Sent: 15 August 2026 08:59
To: DC Admin
Subject: 2025/93355 Land off Woodward Court, Mirfield
Attachments: Screenshot_20260815_084707_Email.jpg

Image 3.4 Proposed Hepworth Lane Site Egress

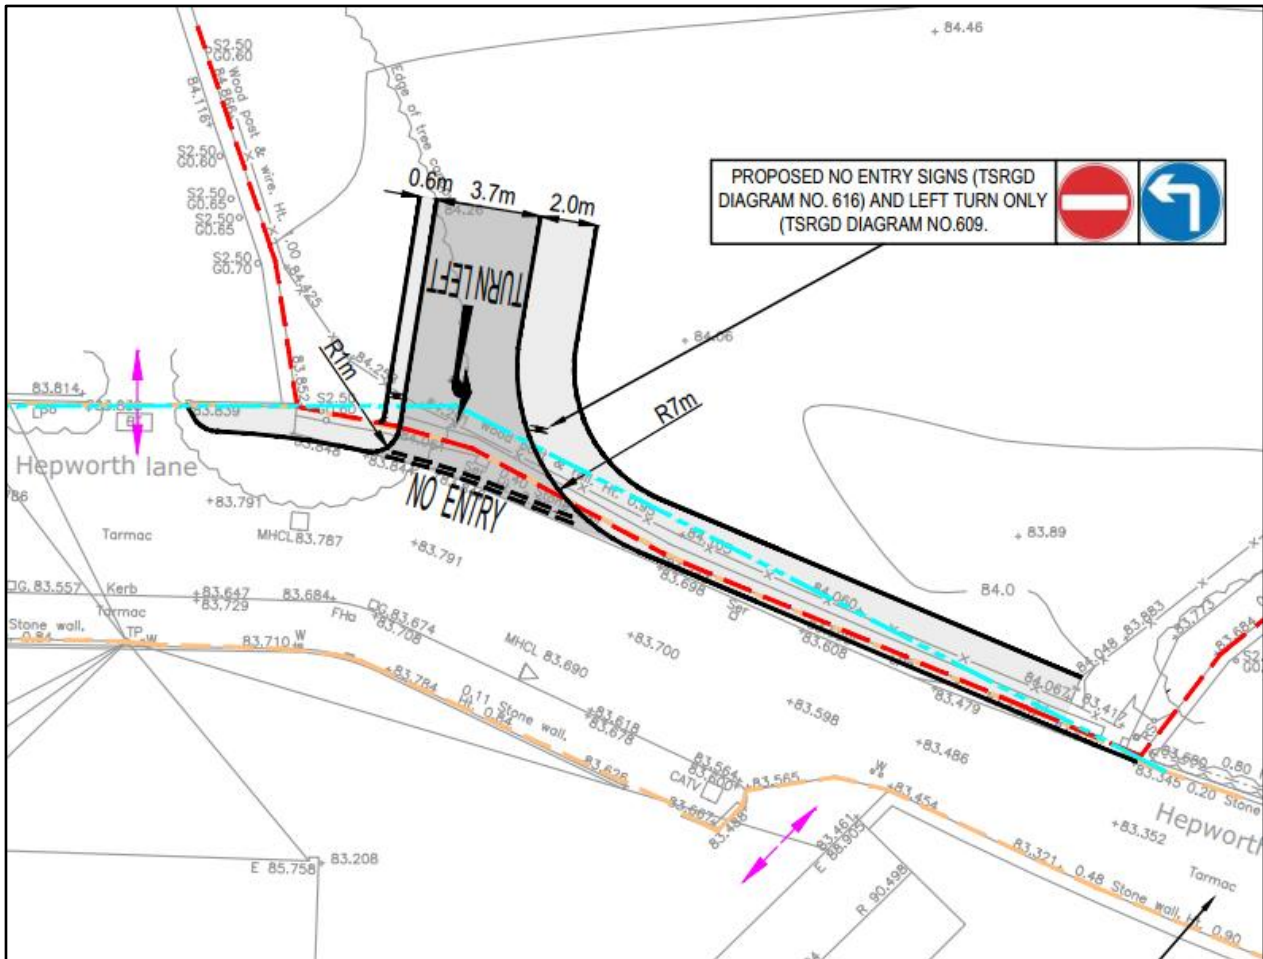
It is proposed that there will be a footway to the west of this exit of only 1.2m (substandard) as far as Hepworth Close. These plans do nothing to improve the situation and are potentially dangerous.
